FORMAL STRATEGIC OBJECTION: STATE SIGNIFICANT DEVELOPMENT

Development Project: 138 Maroubra Road Mixed-Use Proposal (SSD-81426710)

Objecting Party: Surrounding Locality Residents & Adjoining Neighbours

SHADOW CAST BY
EXISTING BUILDING

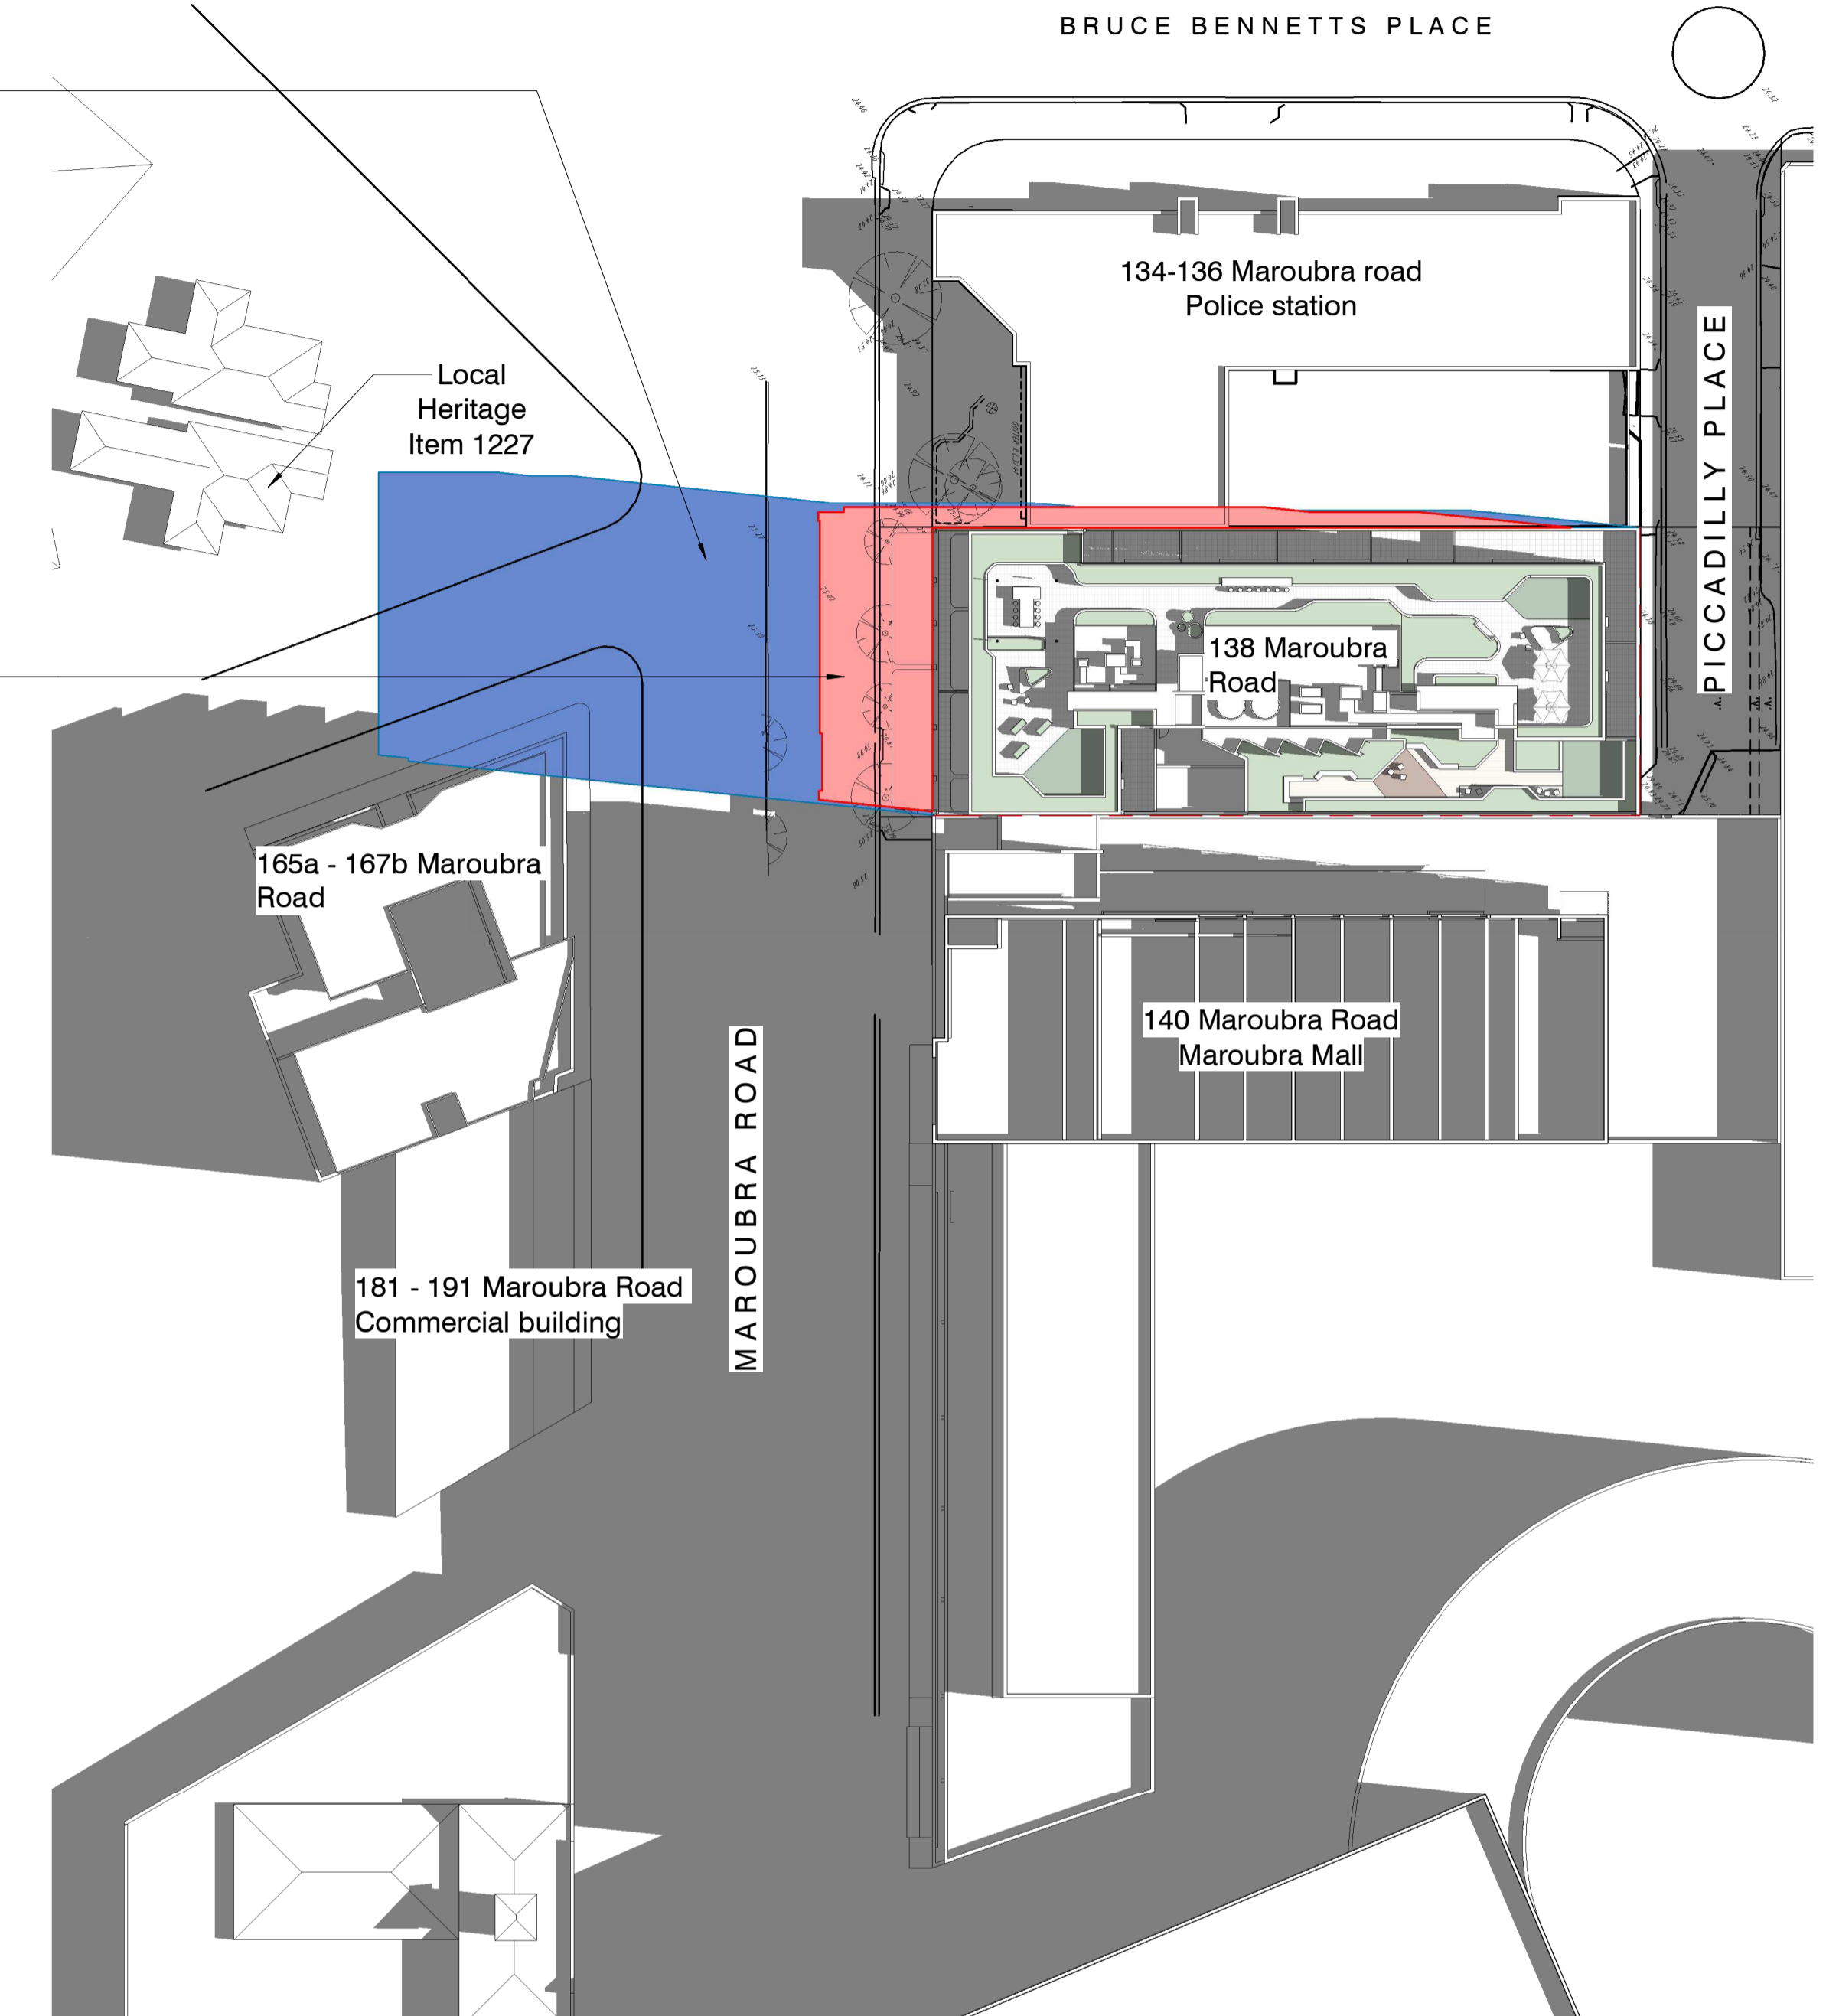
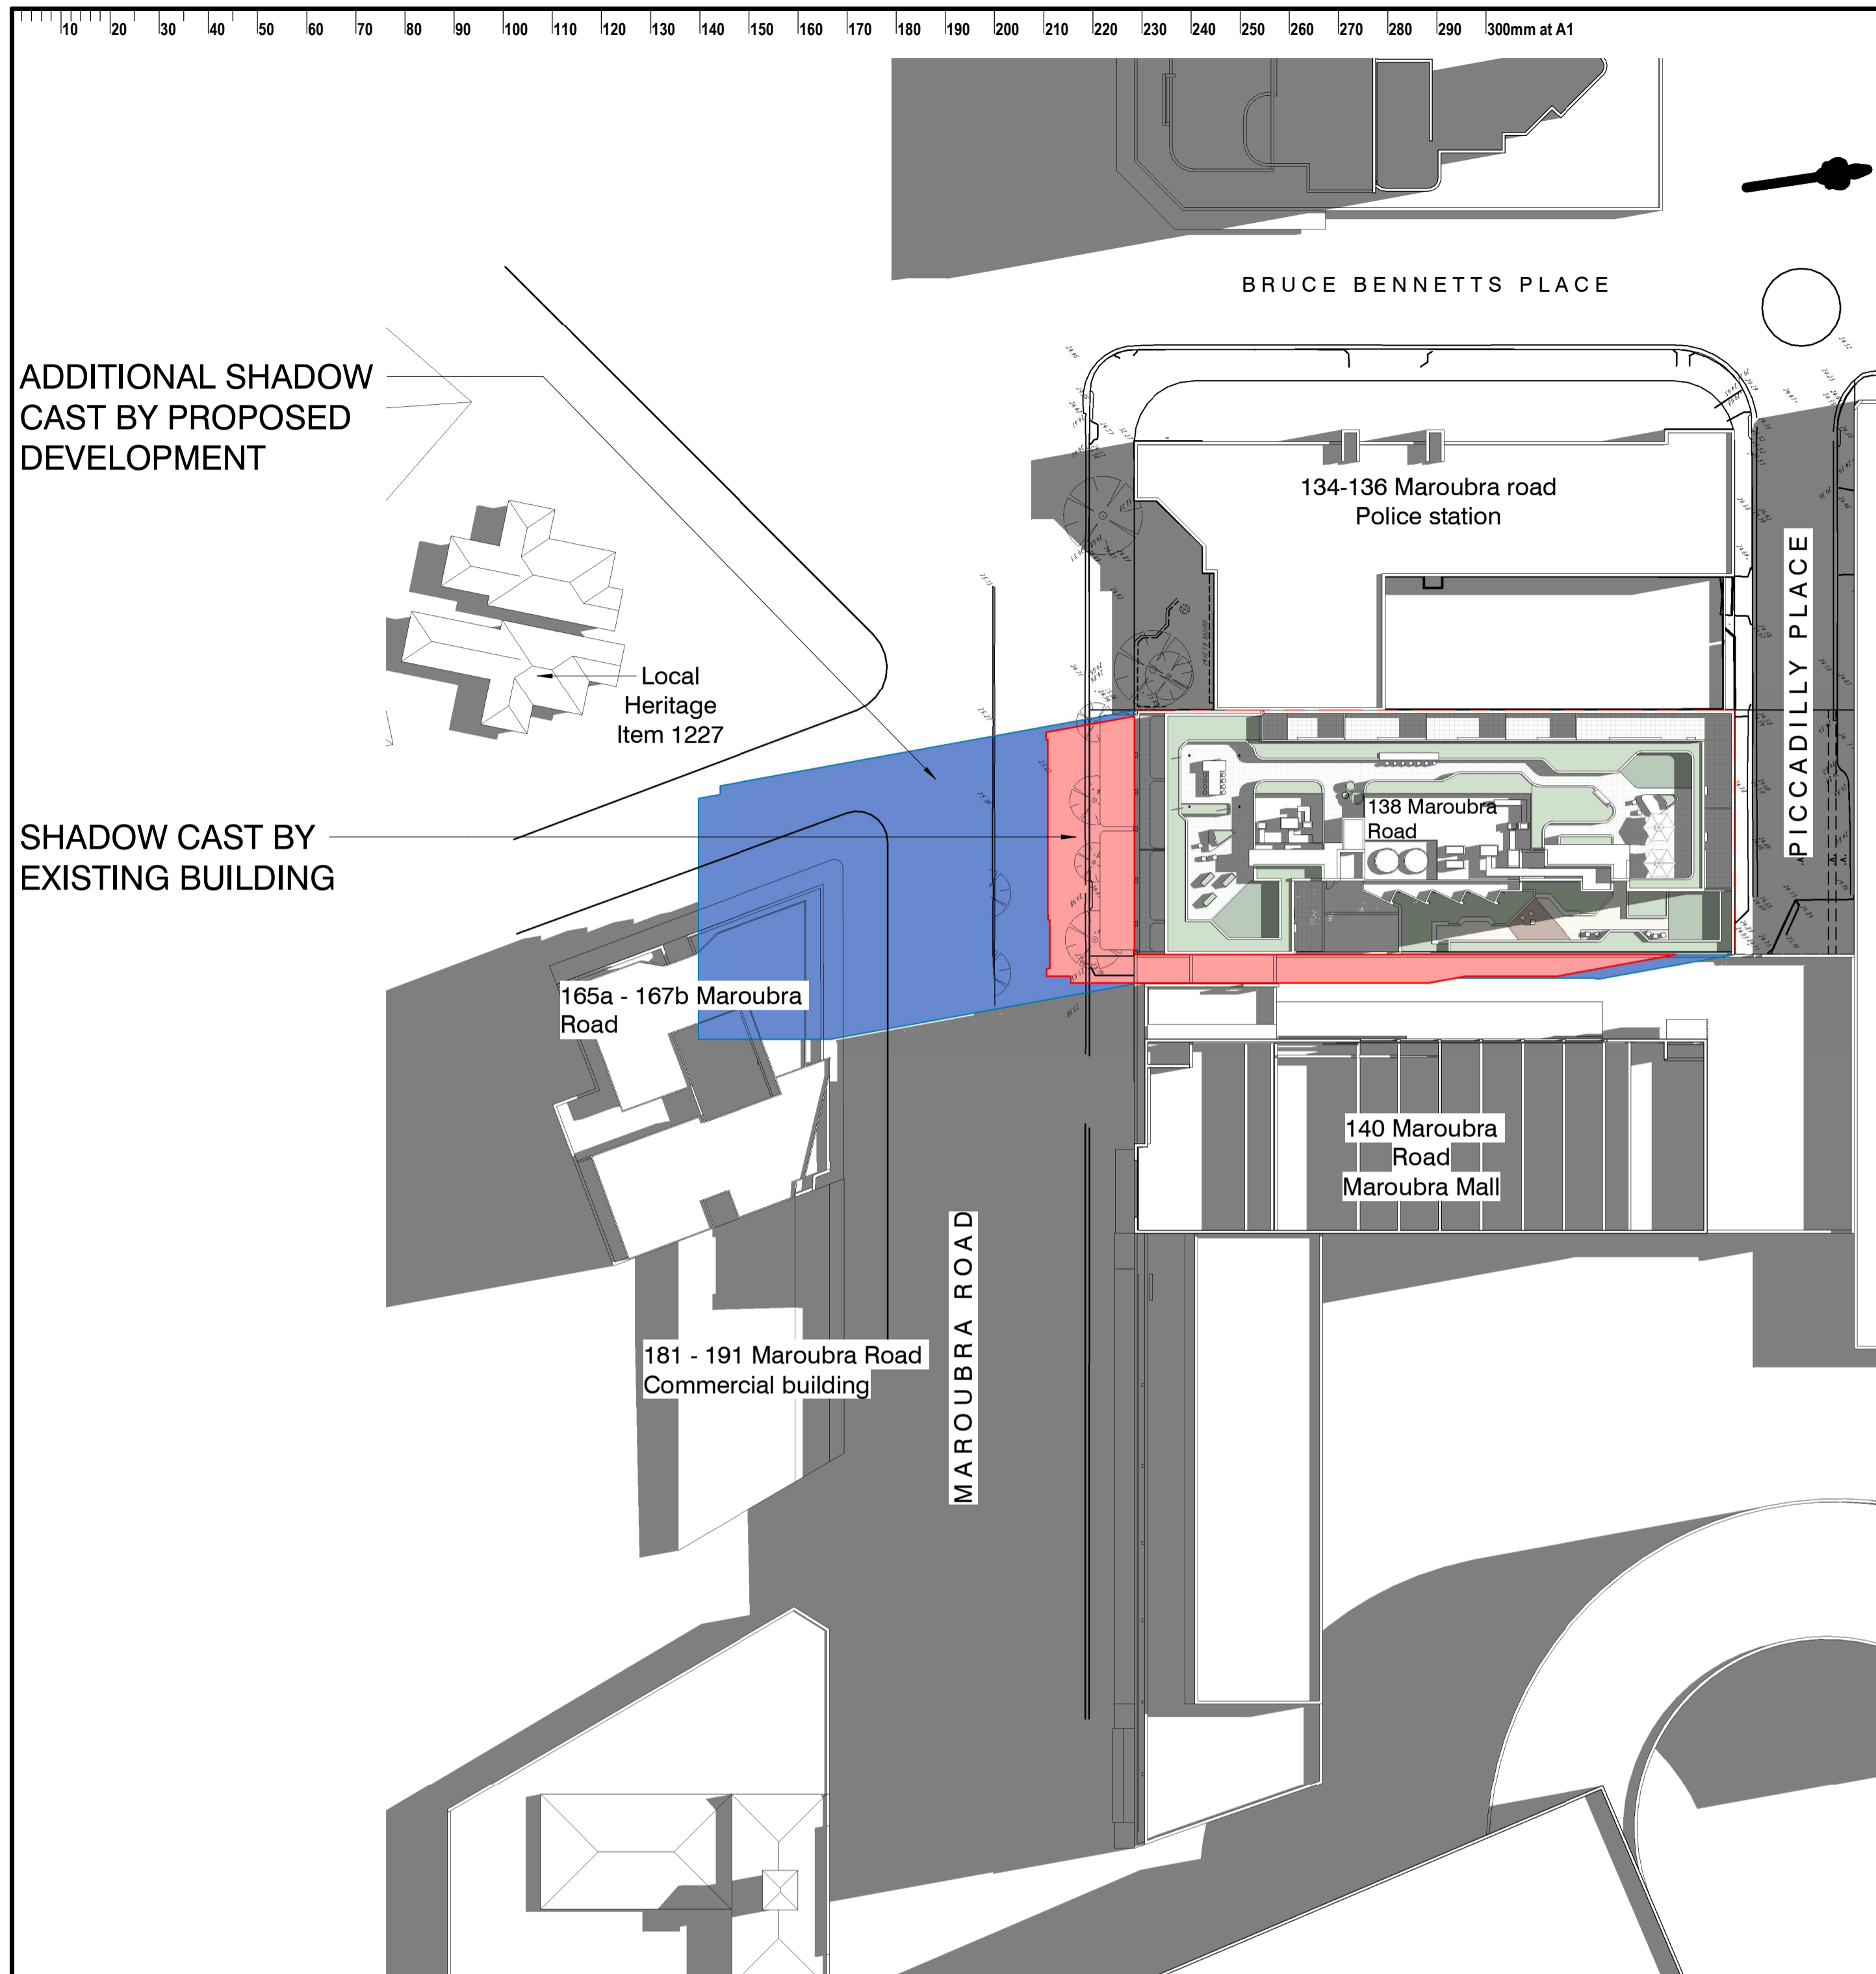
The applicant's submitted shadow modeling relies on broad, regional averages under the Apartment Design Guide (ADG), completely overlooking the localized microclimatic reality of adjoining homes. Building a deep, vertical 10-storey structure directly to the west completely cuts off essential afternoon daylight.

Natural sunlight is a basic requirement for health, physical comfort, and natural apartment temperature control. Stripping adjacent homes of afternoon light hours degrades the baseline well-being of the surrounding community. This loss is felt most acutely by our less-mobile senior residents who stay indoors and rely heavily on natural sunlight for physical health and daily internal warmth.
